WEST SUSSEX COUNTY COUNCIL CONSULTATION

TO:	Arun District Council FAO: Mr Z Denton
FROM:	WSCC - Highways Authority
DATE:	25 January 2021
LOCATION:	18A River Road Littlehampton BN17 5BN
SUBJECT:	LU/312/20/HH Part conversion of garage to create an self contained annex
DATE OF SITE VISIT:	n/a
RECOMMENDATION:	Advice
S106 CONTRIBUTION TOTAL:	n/a

proposed ground floor plan:
No change to elevations:

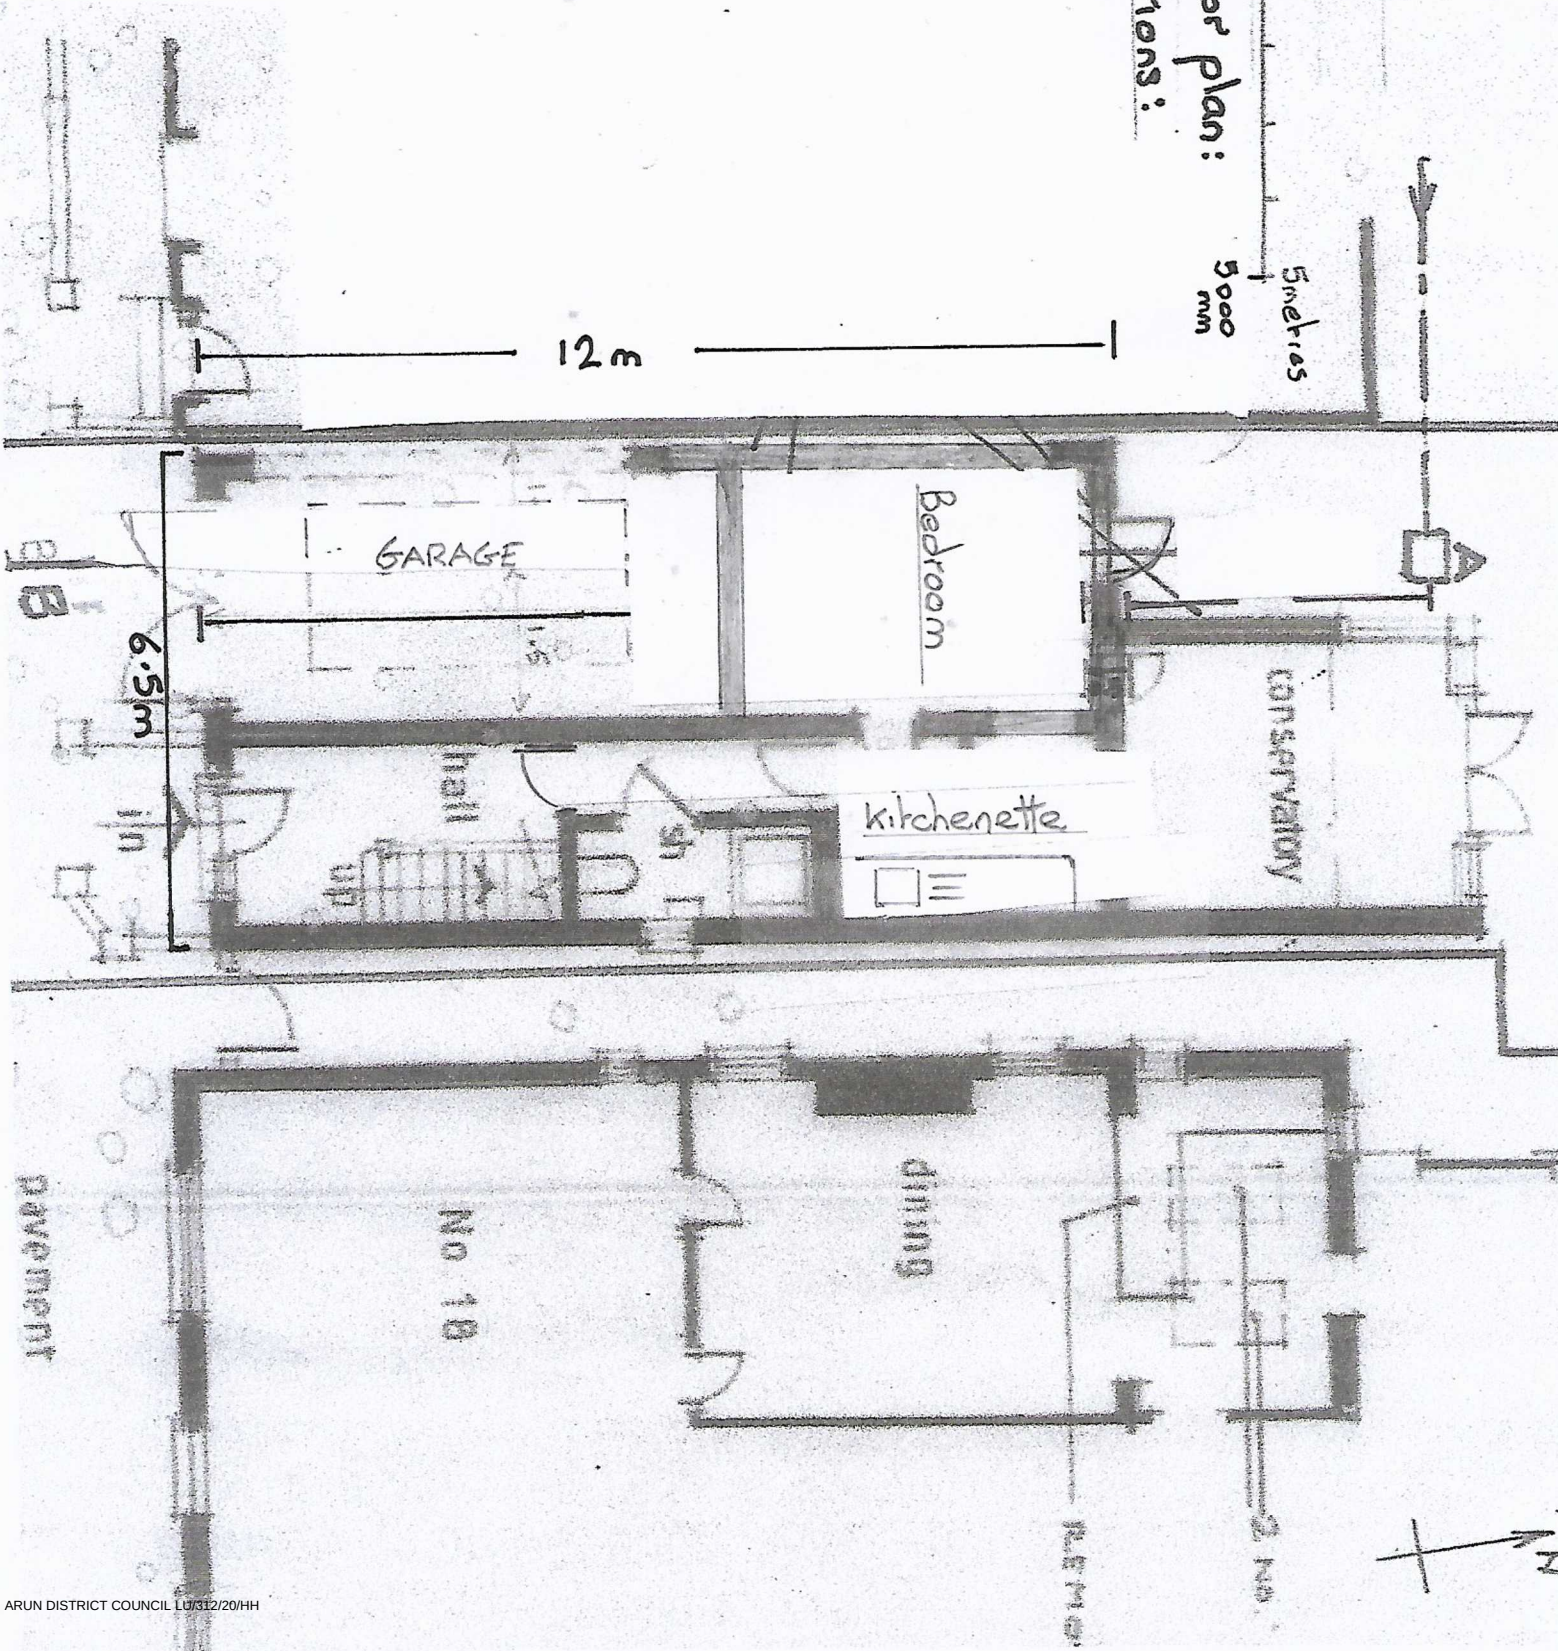
The proposed will result in one suitably sized garage space remaining to serve 18a River Road. This garage space is sized such that it could also accommodate cycle parking. 18a River Road will effectively become a 3-bed dwelling.

It would therefore be concluded that the existing situation (2 bed dwelling with tandem garage) did meet the anticipated parking demand (1 space), with each garage space counting as 0.5 of a space. The proposed (3 bed dwelling with single garage space) will result in the shortfall of 1.5 spaces compared to the anticipated demand of 2 spaces.

It would be concluded that the proposed may result in a small amount of on-street parking demand being created due to the loss of the 2nd garage space and increased

size of habitable accommodation. However, it is extremely difficult to substantiate that small degrees of on street parking in urban settings such as this, where Traffic Regulation Orders protect against unsafe parking, will result in a highway safety issue. The Local Planning Authority may wish to consider any amenity implications.
